BUILDING CODE OF AUSTRALIA REPORT

**Proposed DFS Galleria Building
Refurbishment Works -
155 George Street, Sydney NSW 2000**

Date	Revision Number	No. of pages	Issue or Description of Amendment	Checked By	Approved By	Date Approved
3.12.14	01	18	Draft	Tracey McCann	Vanessa Batty	3.12.14

01 NORTH LONG SECTION AA
Scale: 1:100

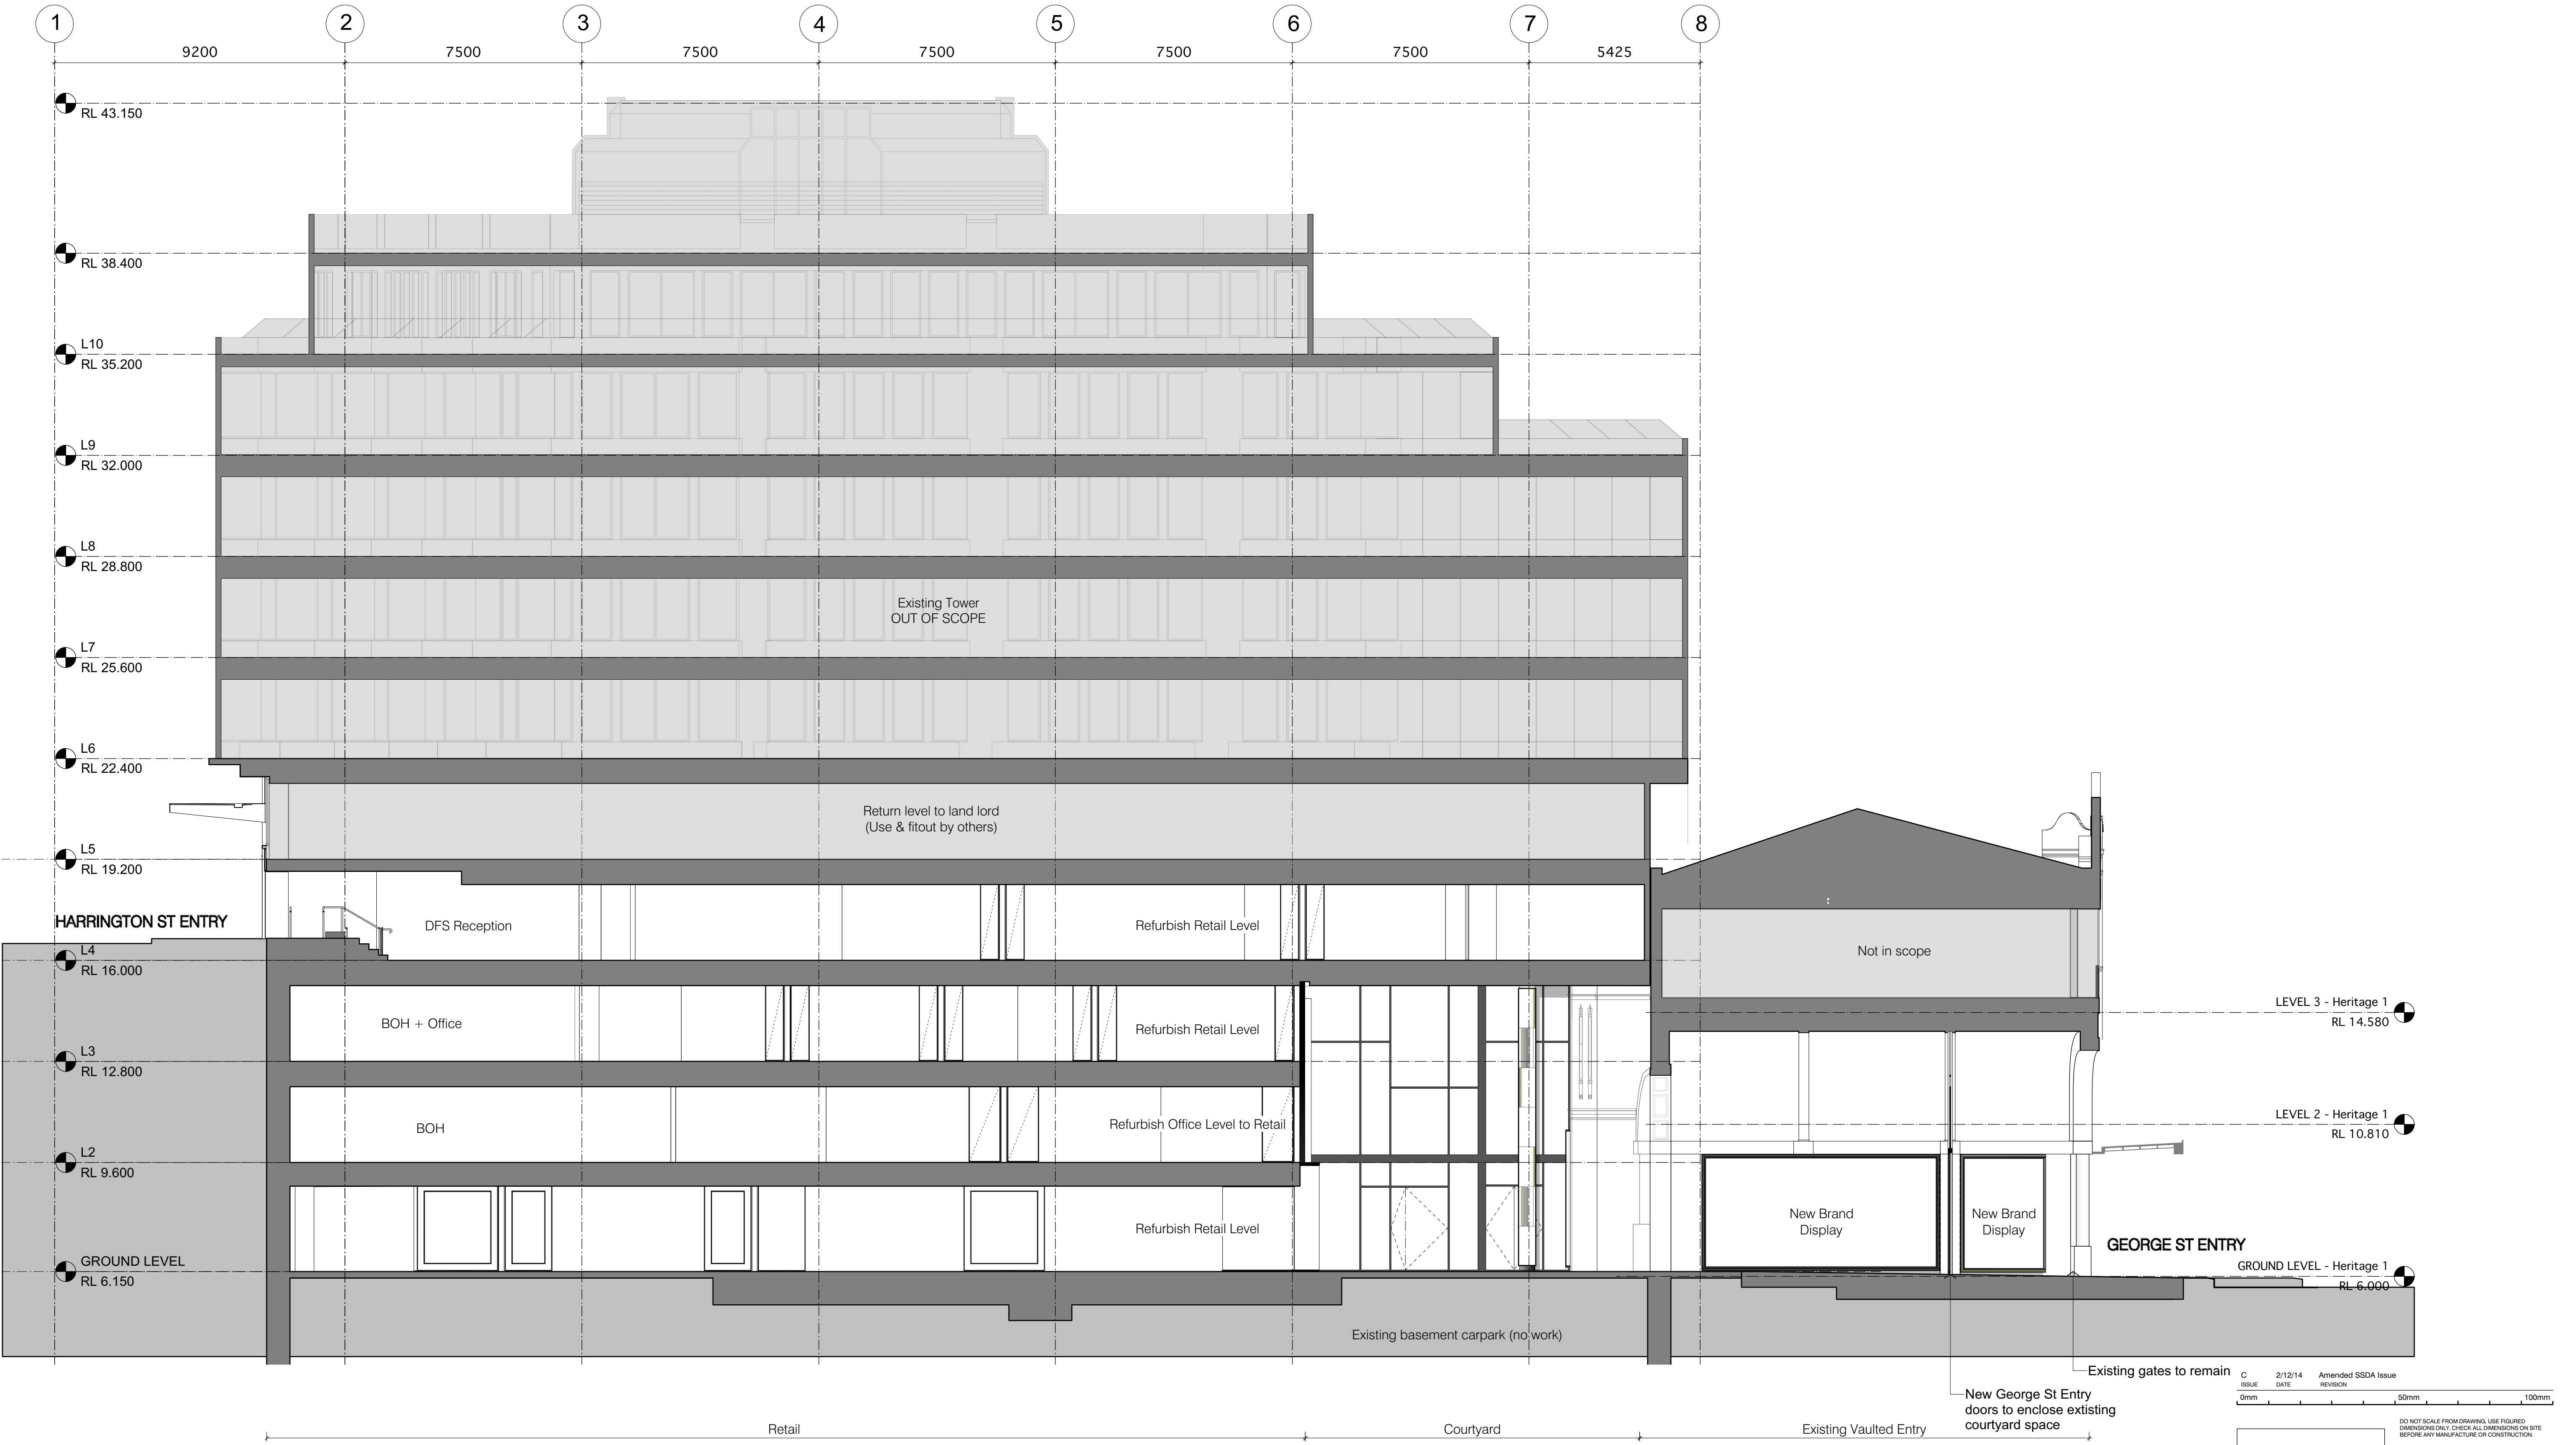
D1.7 & C3.4	Discharge of Fire Isolated exits The enclosure of the atrium space will result in new openings in the external wall which occupants will need to pass on the path of travel to the road along the northern facade. The FRL of the external wall and protection of openings are to be addressed in the Fire Engineering Report verifying compliance with CP2 and DP5.	CP2 & DP5
D1.12 & Spec D1.12	Travelator and Escalators The proposed escalators will connect four (4) storeys in lieu of 3 storeys as prescribed in the BCA for a sprinkler protected building and the escalators are not proposed to be provided with bounding construction to BCA Spec D1.12 (i.e. FRL	CP4 & EP2.2

The enclosure of the atrium space will result in new openings in the external wall facing Globe St which occupants will need to pass on the path of travel to the road along the northern façade. In addition, the exits from the tower stair which discharge along the southern facade of the building involve passing within 6m of the external walls and openings of the existing building.

The enclosure of the atrium space will result in new openings in the external wall facing Globe St which occupants will need to pass on the path of travel to the road along the northern façade. In addition, the exits from the tower stair which discharge along the southern facade of the building involve passing within 6m of the external walls and openings of the existing building.

The FRL of the external wall and protection of openings are to be addressed in the Fire Engineering Report verifying compliance with CP2 and DP5.

The FRL of the external wall and protection of openings are to be addressed in the Fire Engineering Report verifying compliance with CP2 and DP5.

01 LEVEL 3 FIXTURES PLAN
 Scale: 1:100

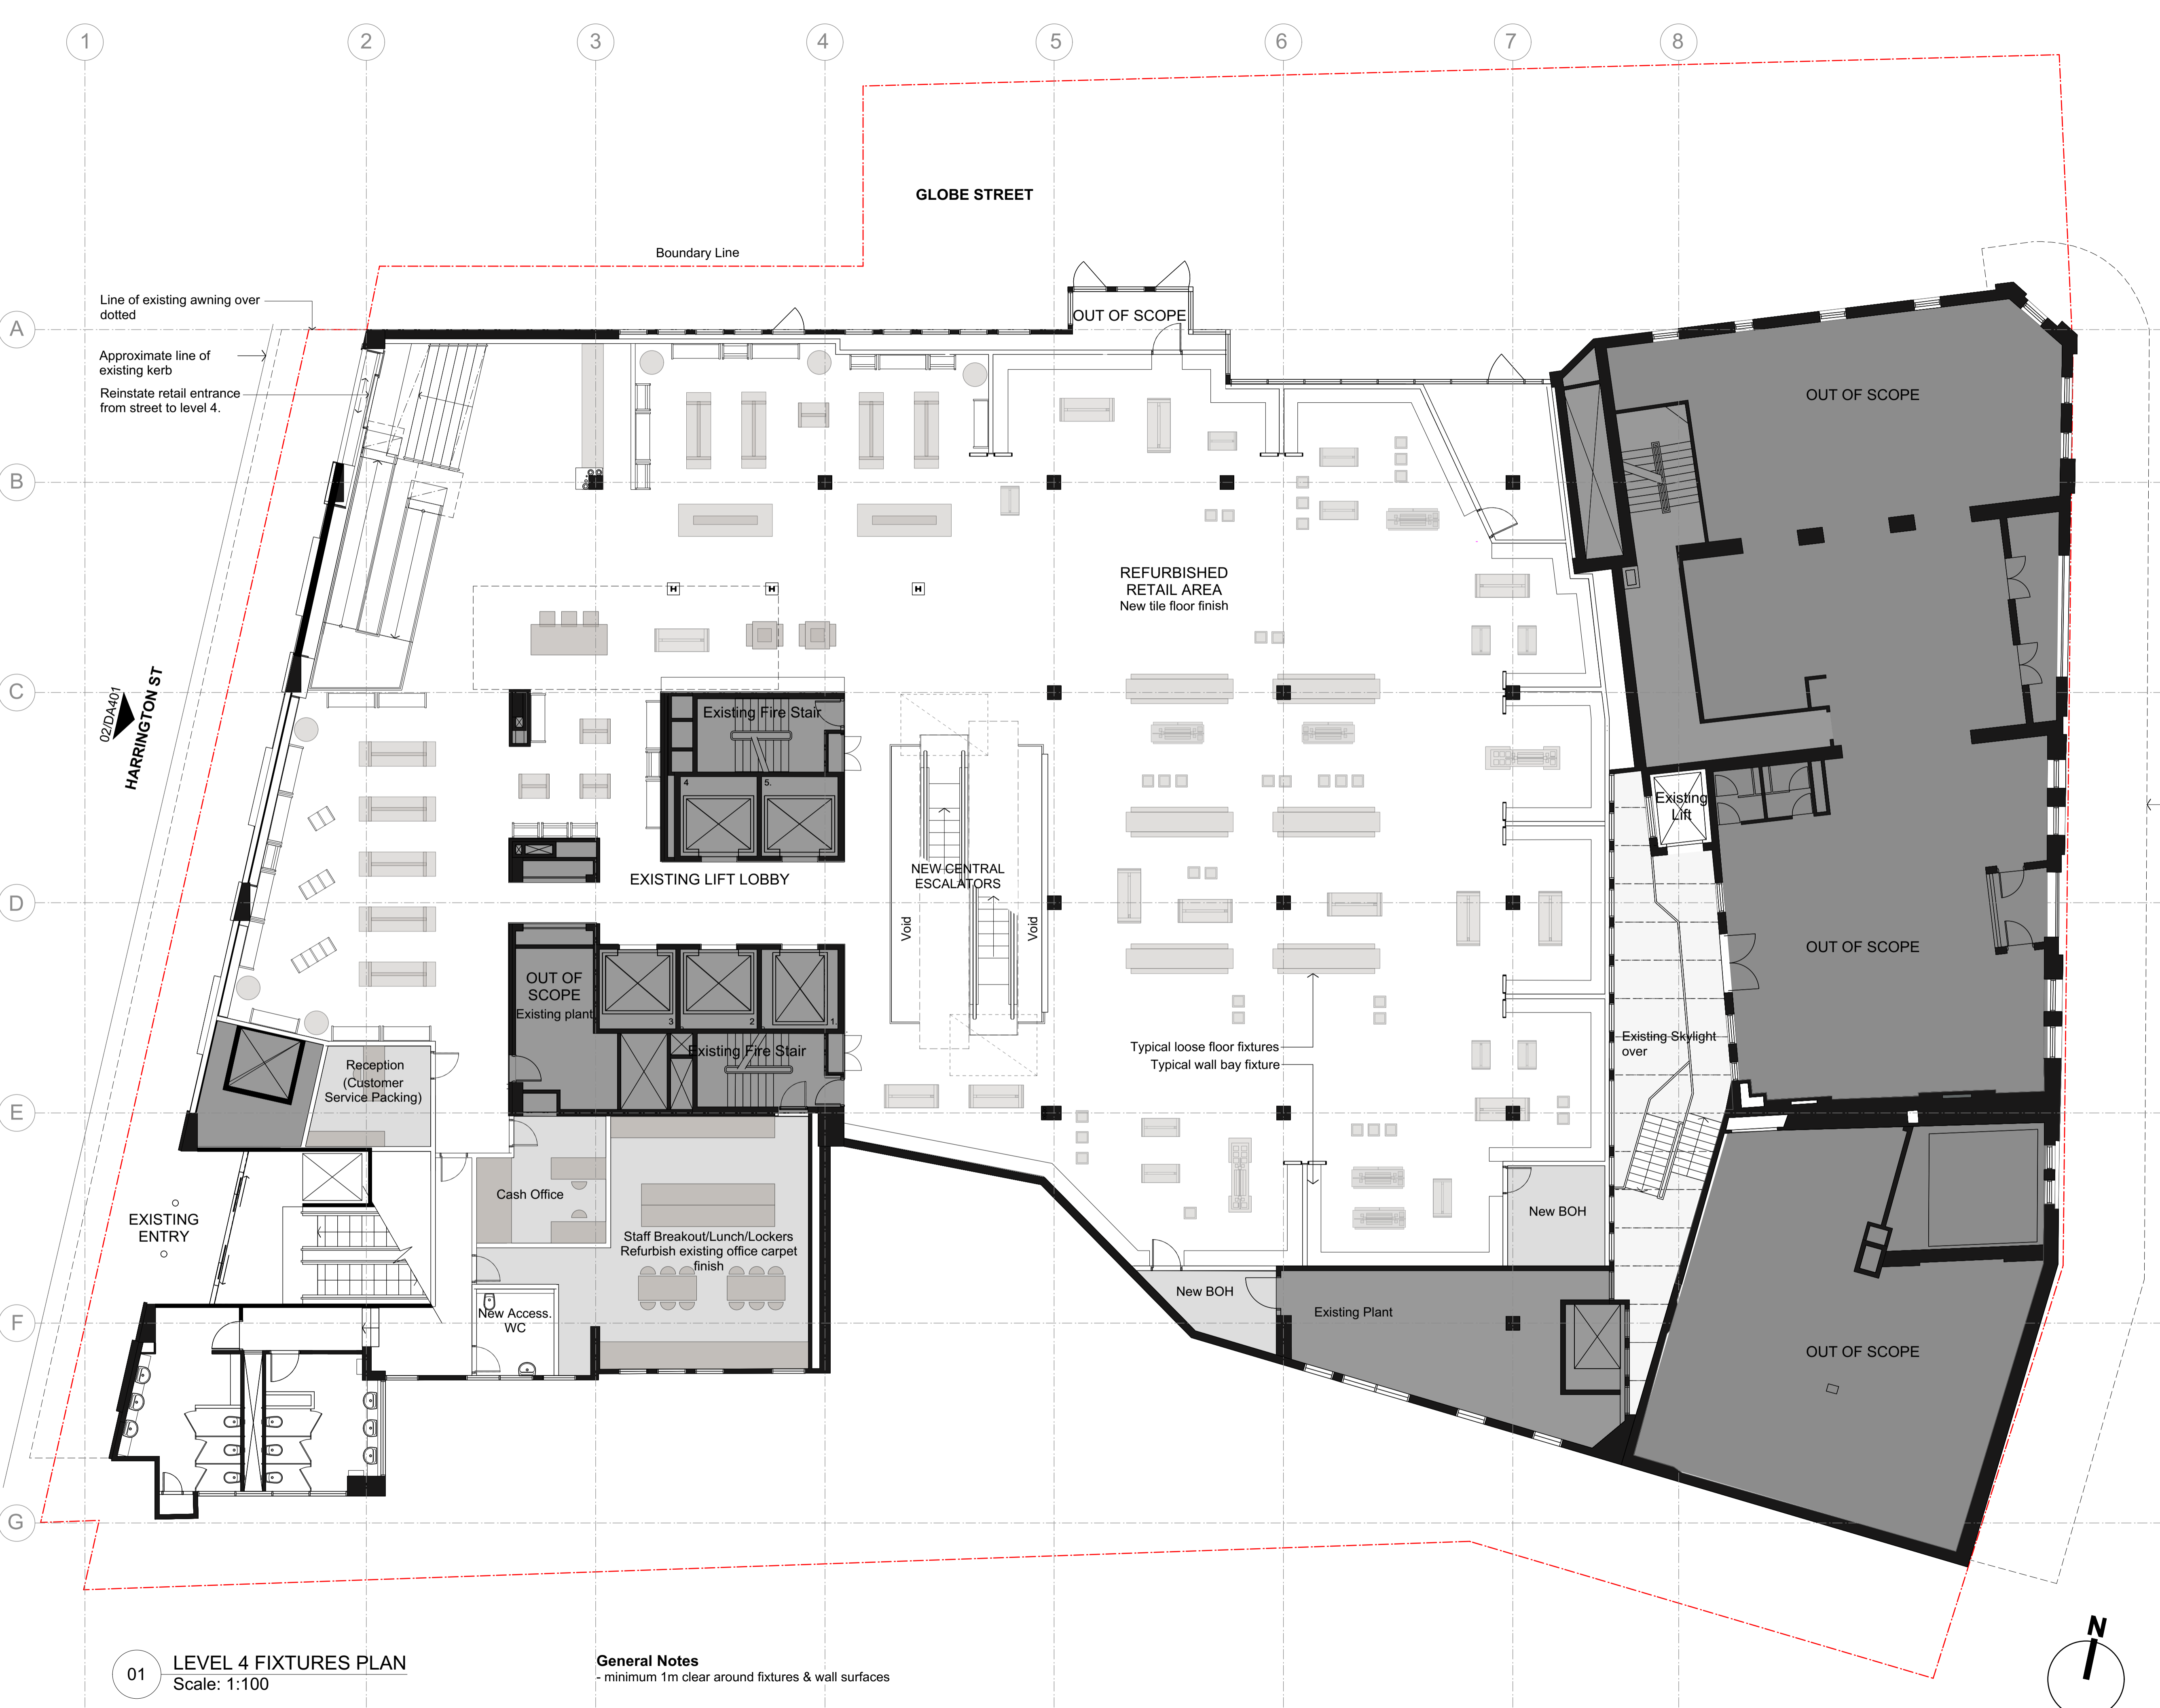
- Travel distance from the open plan office on level 3 to a point of choice is up to 27m in lieu of 20m- further design revisions will be required to comply with DtS provisions of the BCA or alternatively verified by Arup Fire.
